Arun District Council
Arun Civic Centre
Maltravers Road
Littlehampton
West Sussex BN17 5LF
Planning & Building Control General Enquiries
Tel: (01903) 737756 Fax: (01903) 730442
Dx: 57406 Littlehampton
Minicom: 01903 732765
e-mail: planning@arun.gov.uk
website: www.arun.gov.uk/planning

Application No: AB/14/21/HH
Site Address: Riverside House 2 Fitzalan Road Arundel BN18 9JS
Description of works: Reinstatement of timber jetty using existing 3 piles.

Thank you for your internet representation made on 10th March 2021 which has been recorded as an objection with the comments as follows:

**JETTY
EXISTING AND PROPOSED LAYOUT PLAN**

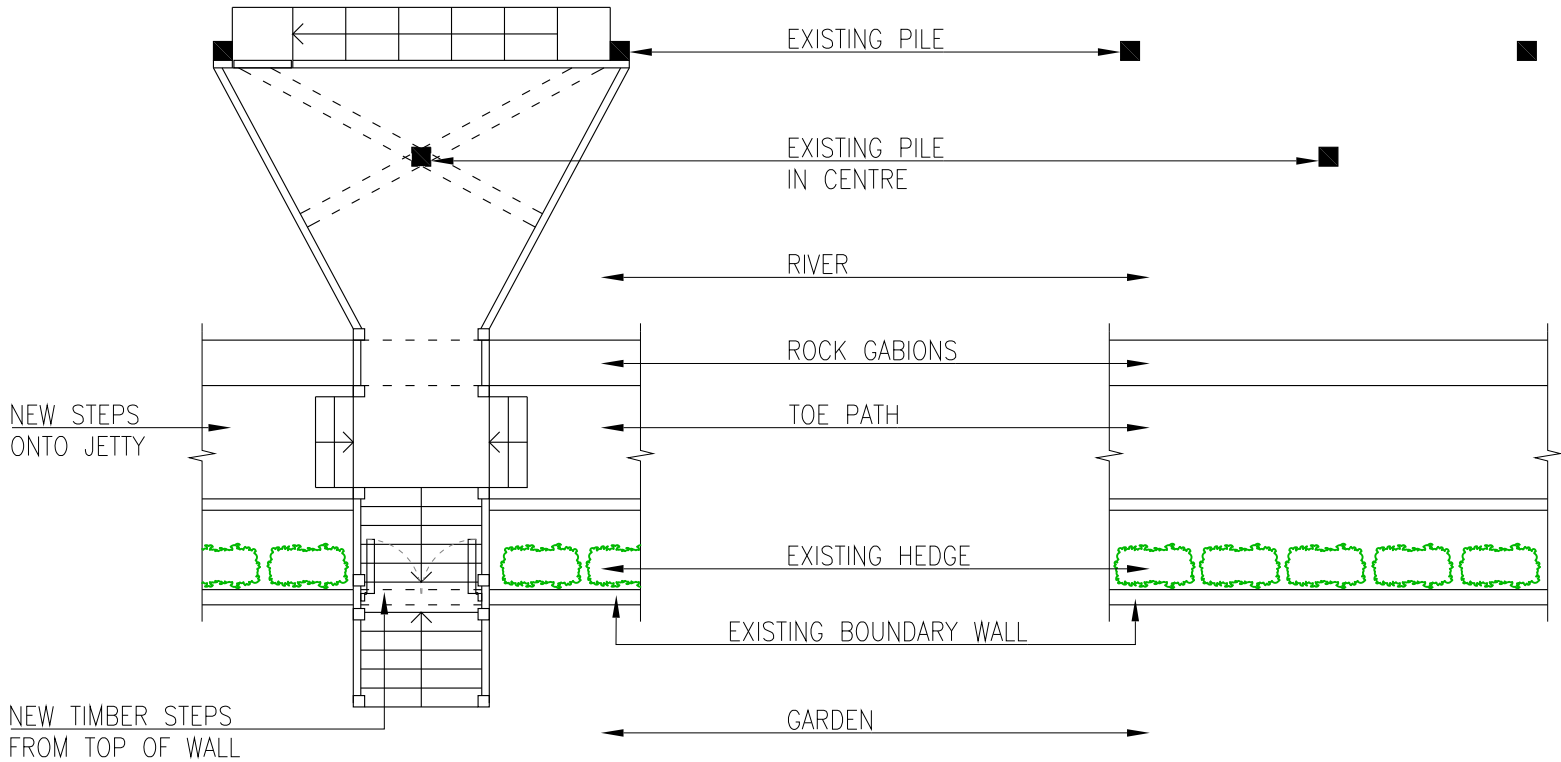
I object strongly to the above application described so simply but, in fact, masking a much bigger project involving the construction of 1) a wooden staircase with handrails 2) a private footbridge with handrails over the flood defence wall 3) a staircase with handrails down to the towpath and 4) a wooden walkway onto a new wooden jetty with handrails and two flights of steps for boarding boats. All in all a large structure which, given its height (including handrails) and size would be an absolute eyesore from so many vantage points along the river, particularly downstream from the Town Bridge, from the properties opposite on the town side of the river and from properties in Fitzalan Road overlooking the river and looking upstream towards the Town Bridge. The latter includes the properties in Otmers Quay, adjacent to Riverside House, where my wife and I live at No 5, all of which would have their view up~river adversely affected, indeed ruined, by such a prominent and obtrusive structure. Such is the scale of the proposed structure that it would have a serious adverse impact on the various amenities and the character of the area, as well as increasing the security risk to the properties overlooking the river. Whilst the proposed new decking on the towpath would create a trip hazard, the proposed structure would also reduce the width of the towpath for people walking along it past Riverside House and increase the risk of accidents. There is, of course, already easy access to the towpath at the side of Martletts Court, which is the neighbouring property to Riverside House.
